Berry, Huff, McDonald, Milligan Inc.
Engineers, Surveyors

October 2, 2013

RE: Site Plan Revisions
Lot 13-Skylark Commons Subdivision

Comments from Philip DiPierro, Development Review Coordinator, dated September 30, 2013:

<p>SITE PLAN-LOT 13</p> <p>SKYLARK COMMONS</p>		<p>FOR Frank Didonato Sr. 87 Skylark Road Portland, Maine 04103</p>	<p>BH2M Berry, Huff, McDonald, Milligan Inc. Engineers, Surveyors</p>	<p>STATE OF MAINE LICENSED PROFESSIONAL ENGINEER LESTER S. BERRY, P.E. No. 3341</p>

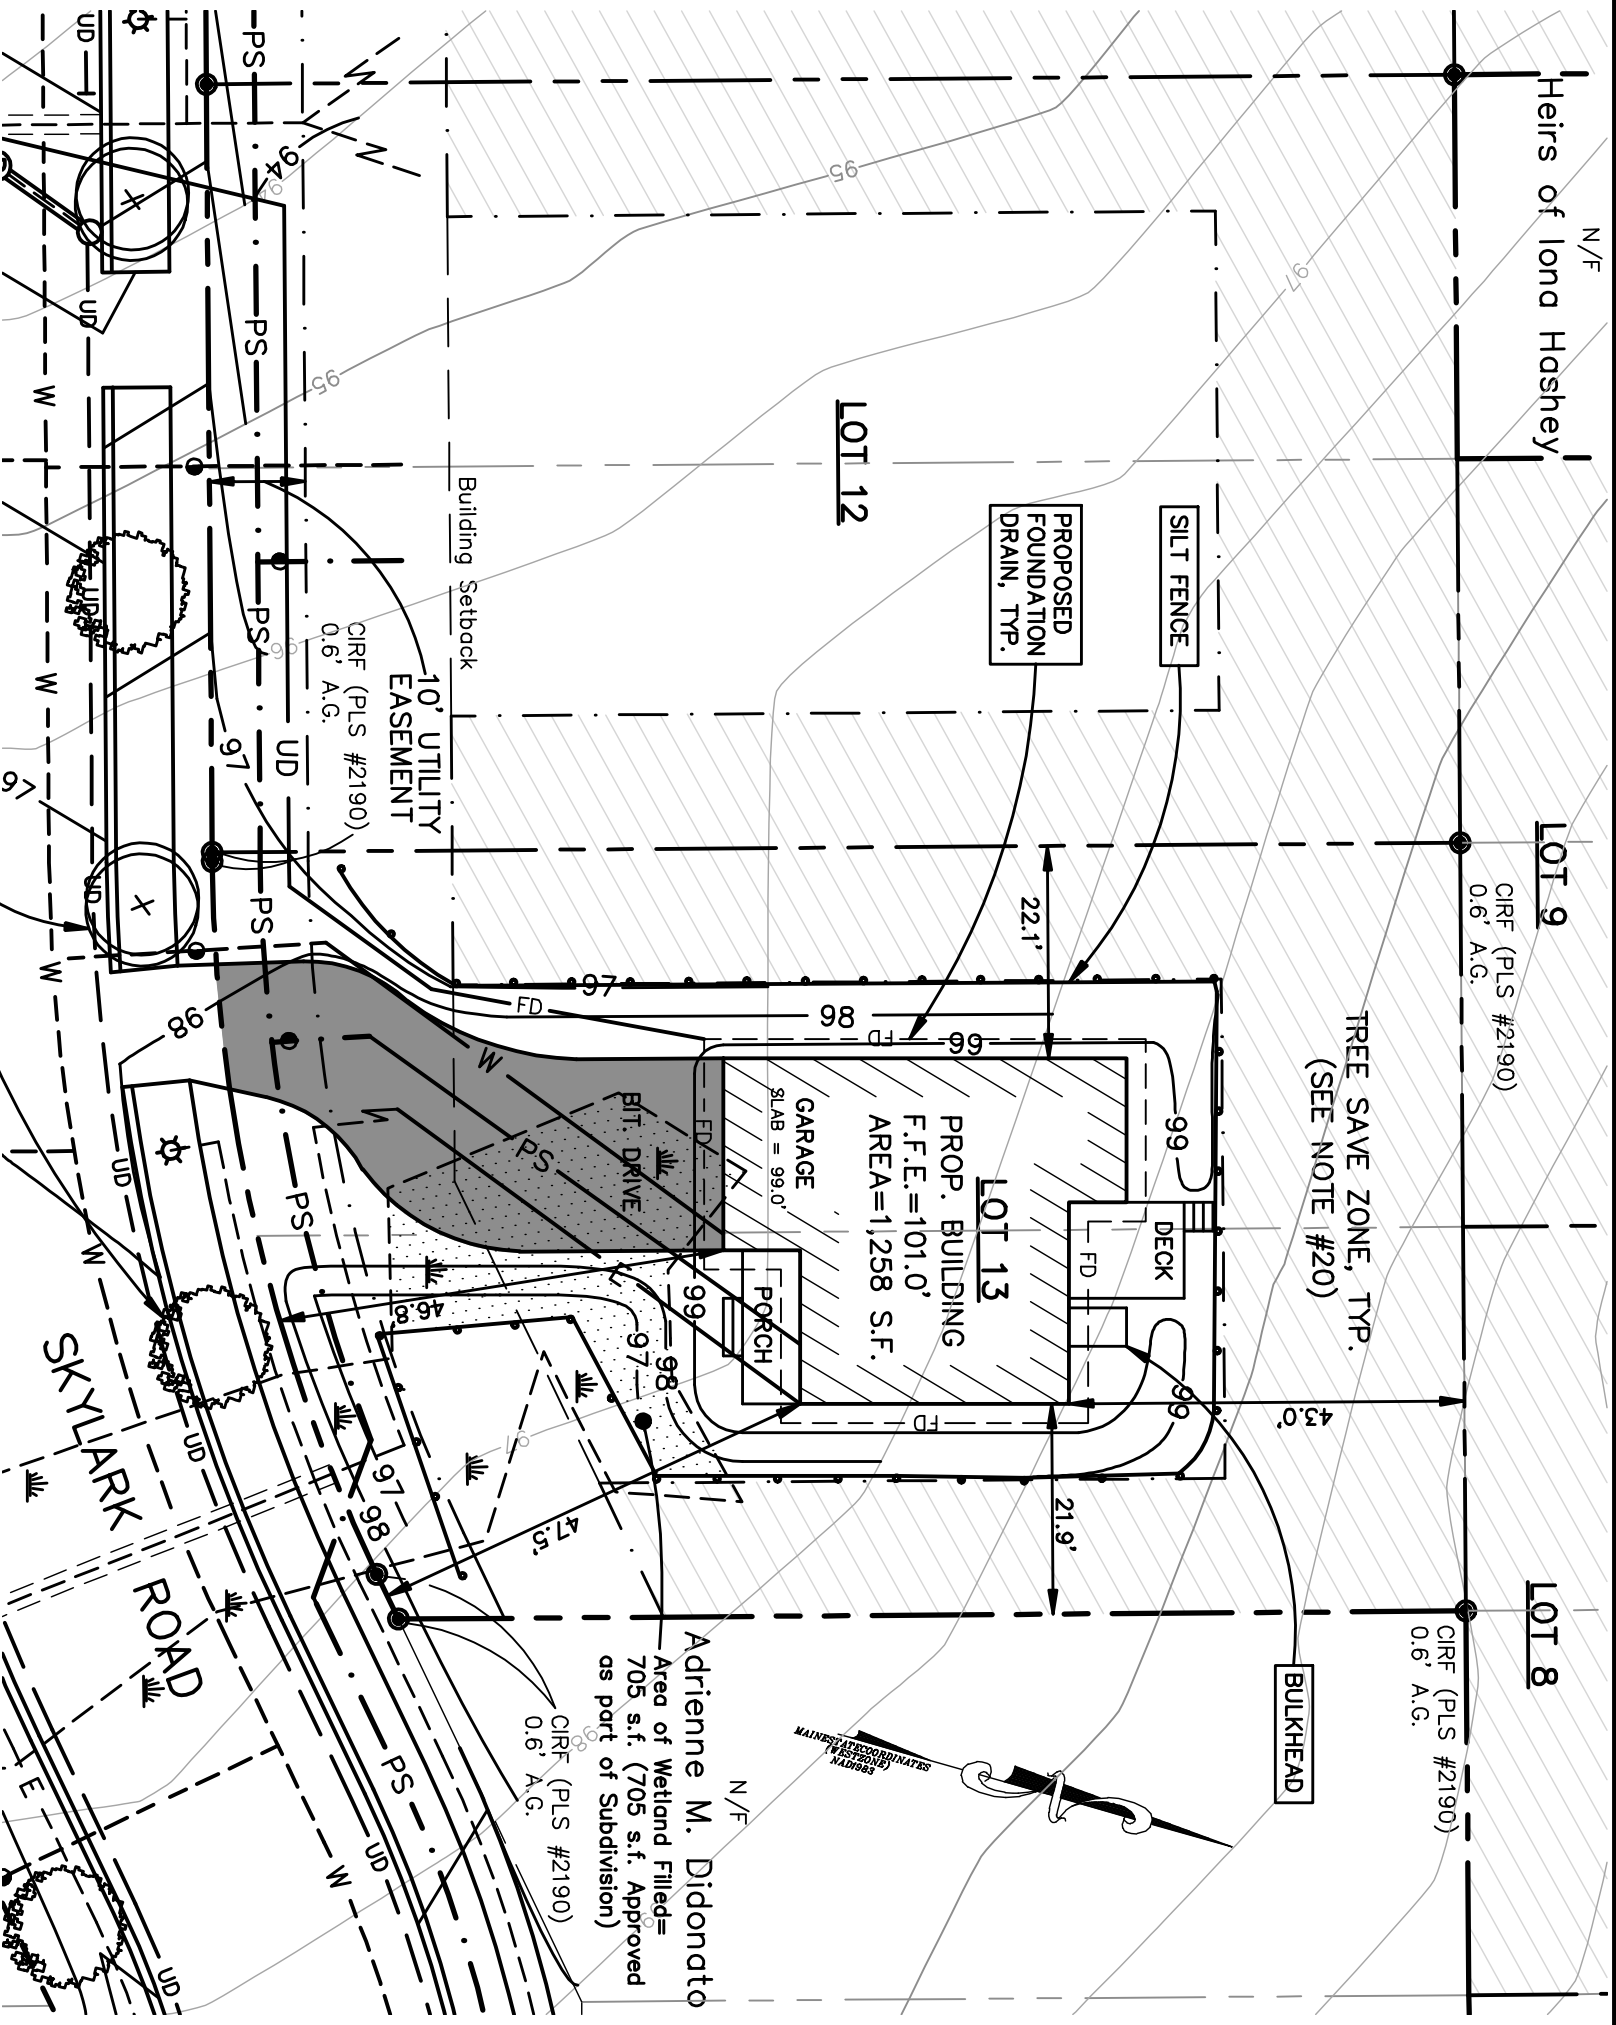
1. Note #18 on the Site Plan has been revised as requested to update the status of Skylark Road to unaccepted.

1. The wetlands have been updated on the plan as requested to match the approved amended subdivision plan (Plan Book 210 Page 345).
2. The wetland impacts have been shown on the plan with a dot hatch (see comment #3 below for more information). All erosion and sediment control techniques to be implemented on the site to protect the wetlands

have been shown on the attached revised Site Plan.

3. The original Site Plan was submitted with a building that was 46.5 feet wide. This revised (attached) Site Plan reflects the current building design which is 36 feet wide. This building size reduction allows additional space on each side of the building for construction access and for the excavation process between the tree save zone and the proposed building. The construction of this lot will be undertaken as have the other lots within this subdivision. The contractor will need to be aware of the limits of the tree save areas to assure that no disturbance is made within these areas. As the other lots have been constructed with minimal and insignificant impacts to the tree save zone, this lot too can be constructed this way as long as the contractor is cautious of these areas. The revised plan shows no impacts to the tree save areas.

The revised plan does show some impacts to the onsite wetlands, however, these impacts do not exceed the approved total for this lot. The Amended Subdivision for this plan shows a total wetland impact of 705 s.f. on Lot 13 within the building setback line. The revised Site Plan for this lot proposes a total wetland impact of 705 s.f. within the building setback (see hatch on attached plan). The impacts as shown on the attached Site Plan are in conformance with the approved Maine DEP NRPA Tier I Wetland Alteration Permit for this project (DEP Permit #L-24212-TB-A-N).

4. The contours on the plan have been adjusted as requested. Please note that as mentioned above the house size has been reduced, therefore, the Eastern side of the house has additional room between the proposed house and the tree save zone, thus, the grading has been adjusted accordingly to be flatter in this area.

5. No adverse impacts will be created to any abutting residences as a result of this project. A foundation drain has been proposed along the perimeter of the house, that will connect to the drainage system within Skylark Road. A ditch has been proposed on the Northern side of the proposed house to direct runoff to the to Skylark Road. The design of this lot meets all of the requirements from the Drainage analysis completed by our office and approved by the City of Portland and Maine DEP as part of this subdivision.

1. As mentioned above the building footprint on the attached Site Plan has been revised to match the building plans.
2. As mentioned above the building footprint on the attached Site Plan has been revised to match the building plans.
3. As mentioned above the building footprint on the attached Site Plan has been revised to match the building plans.
4. The deck has been shown in the location that matches the building plans.
5. The bulkhead has been shown on the Site Plan as requested.
6. The size of the deck has been adjusted accordingly to match the building plans.
